Application for a non-material amendment following a grant of planning permission.

Number	120
Suffix	
Property name	
Address line 1	Laund Road
Address line 2	Salendine Nook
Address line 3	
Town/city	Huddersfield
Postcode	HD3 3TY

Demolition of Existing Dwelling and erection of 7 No. Dwellings	
Reference number:	2019/90486
Date of decision	12/06/2020

Raise Plot 2 by 350mm

SOUTH ELEVATION

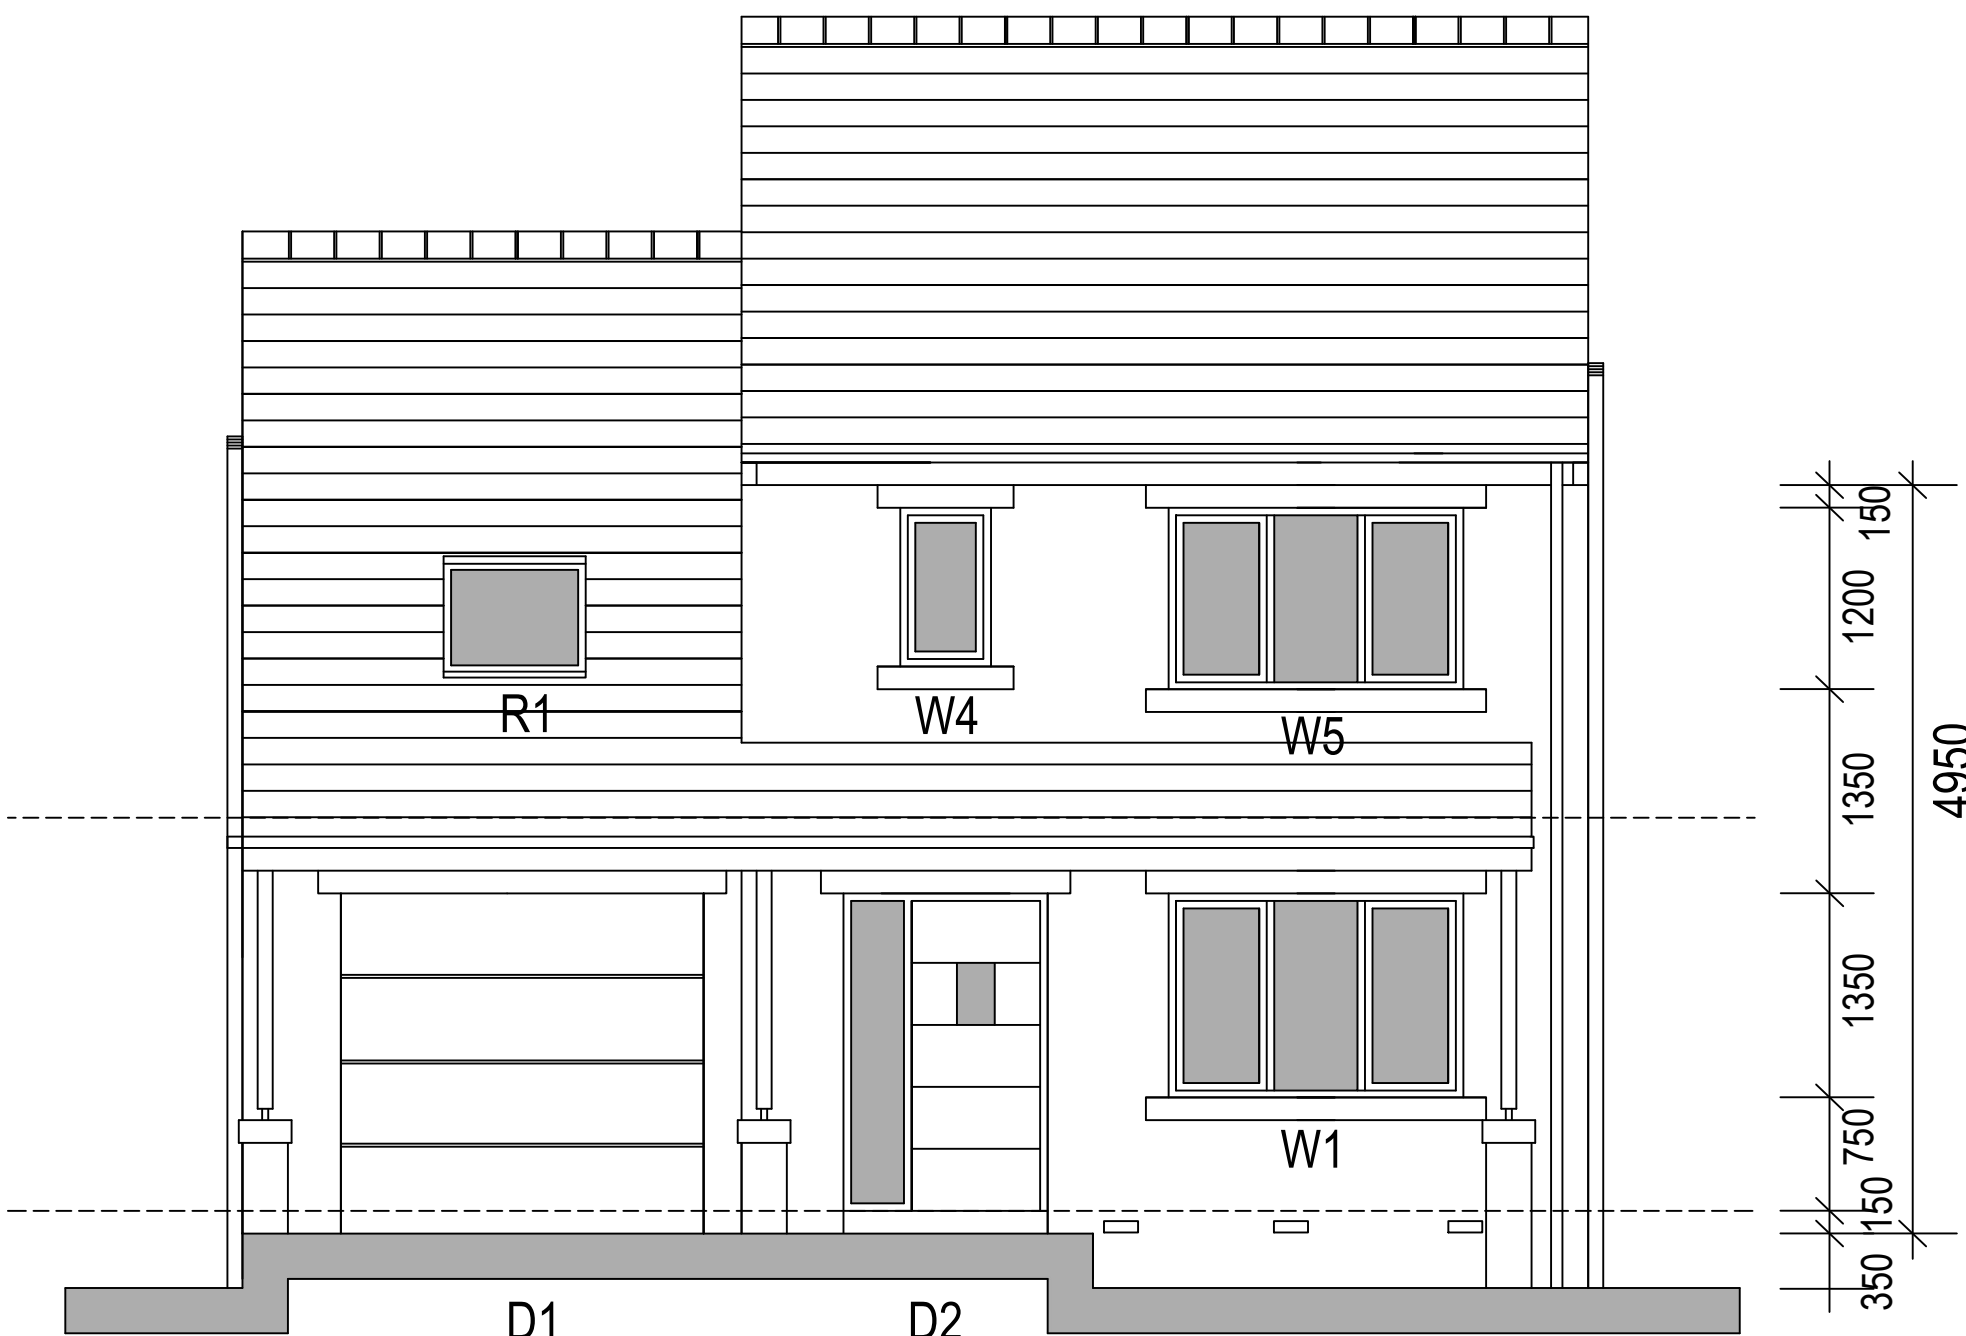
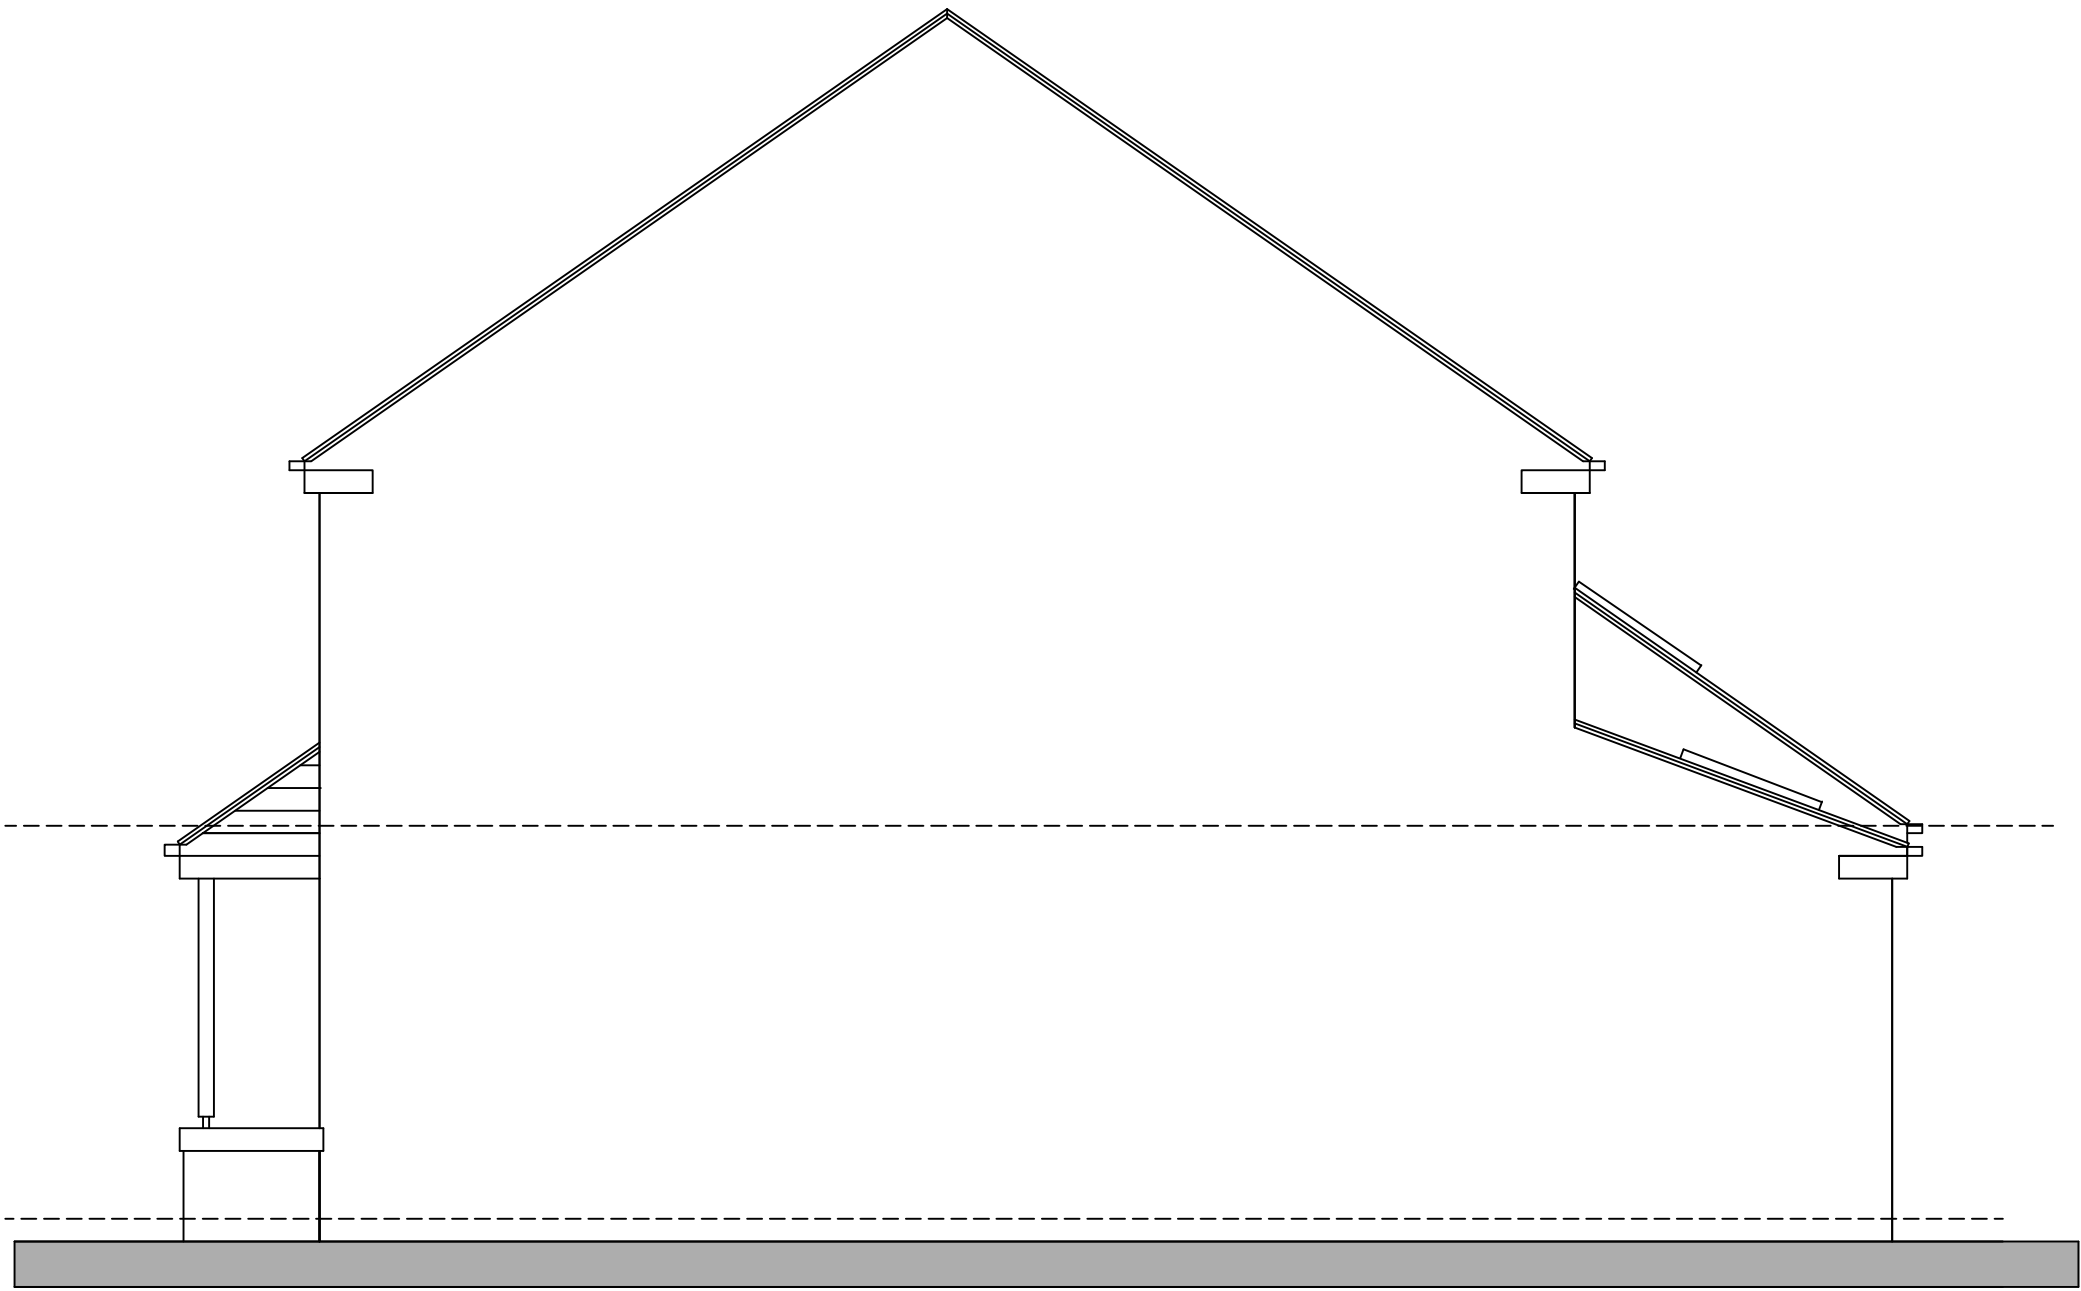
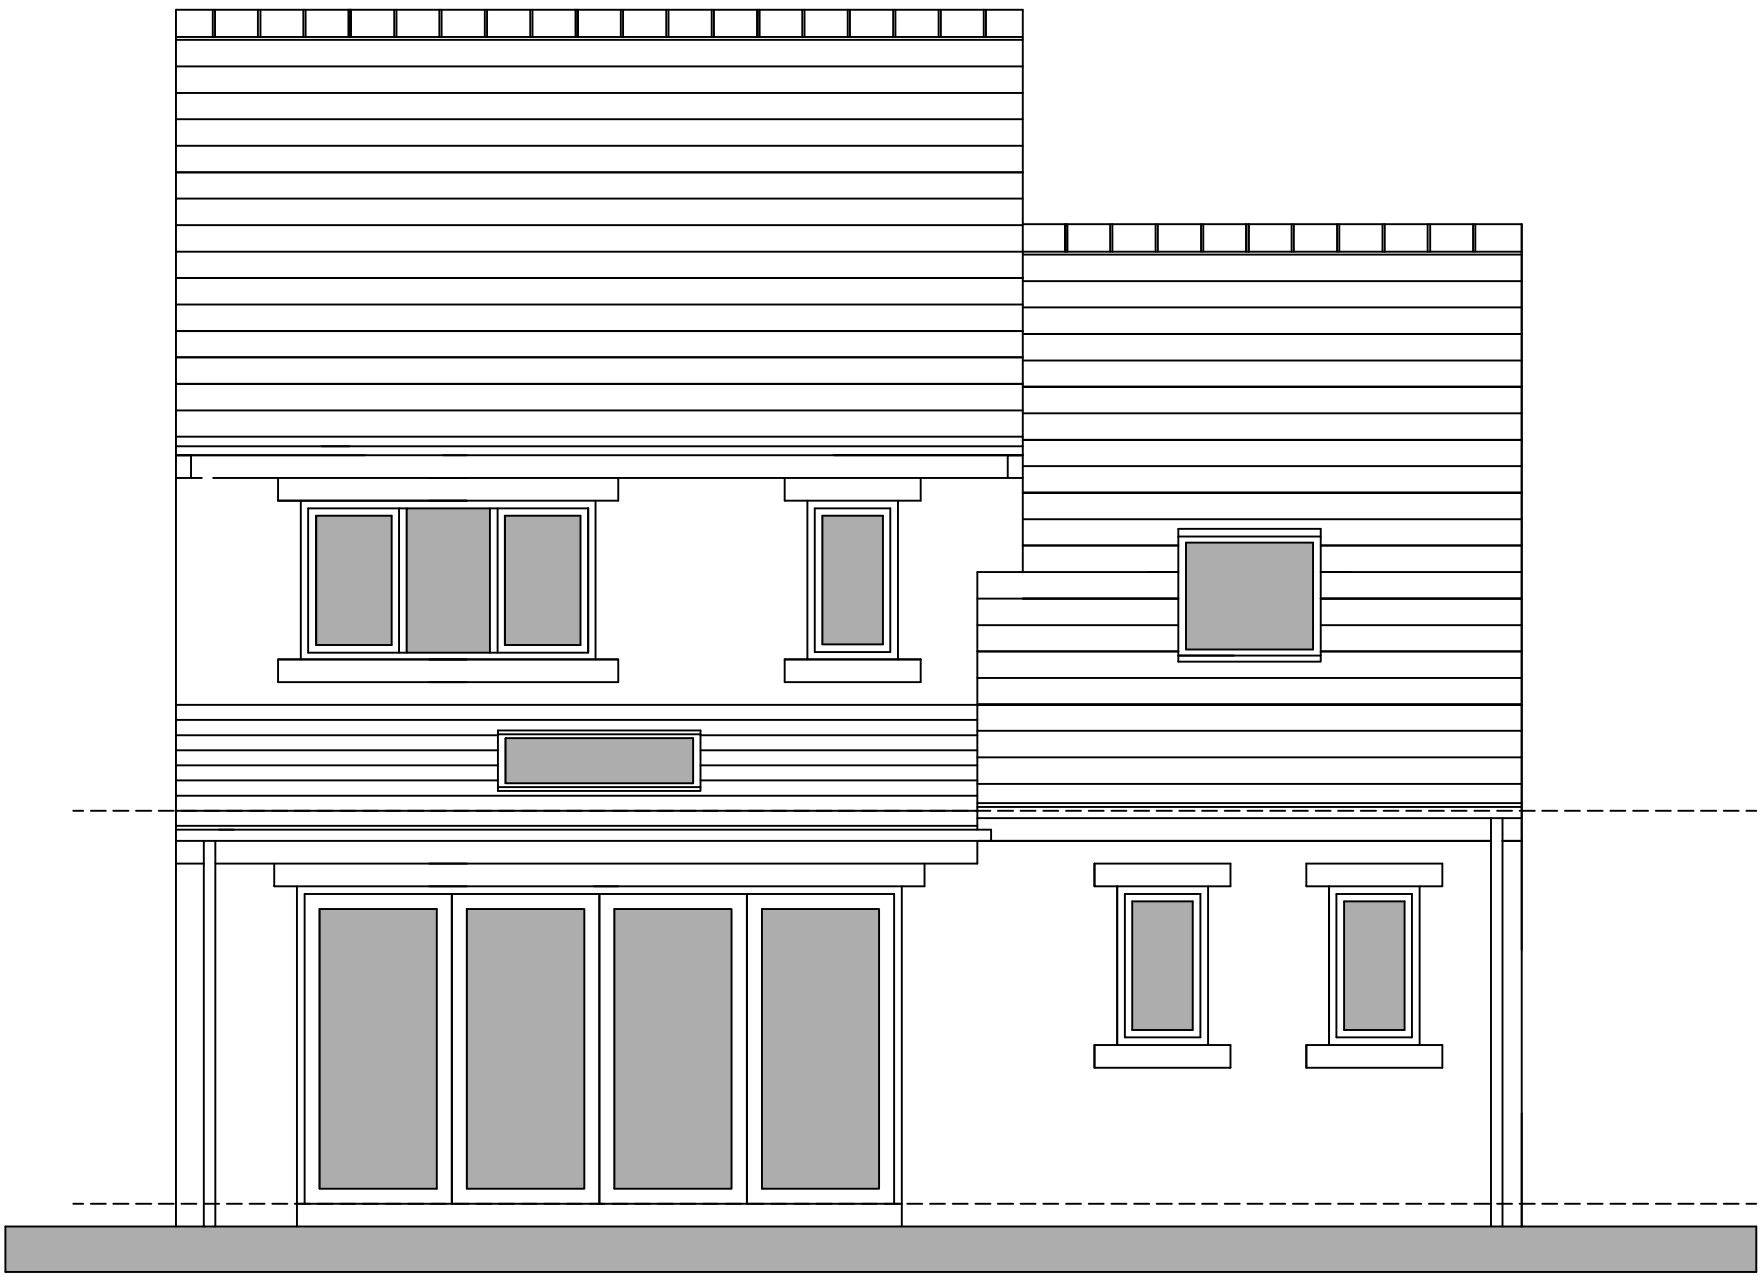
Due to the floor construction changing, from solid to suspended beam and block, due to incorporation of gas membrane
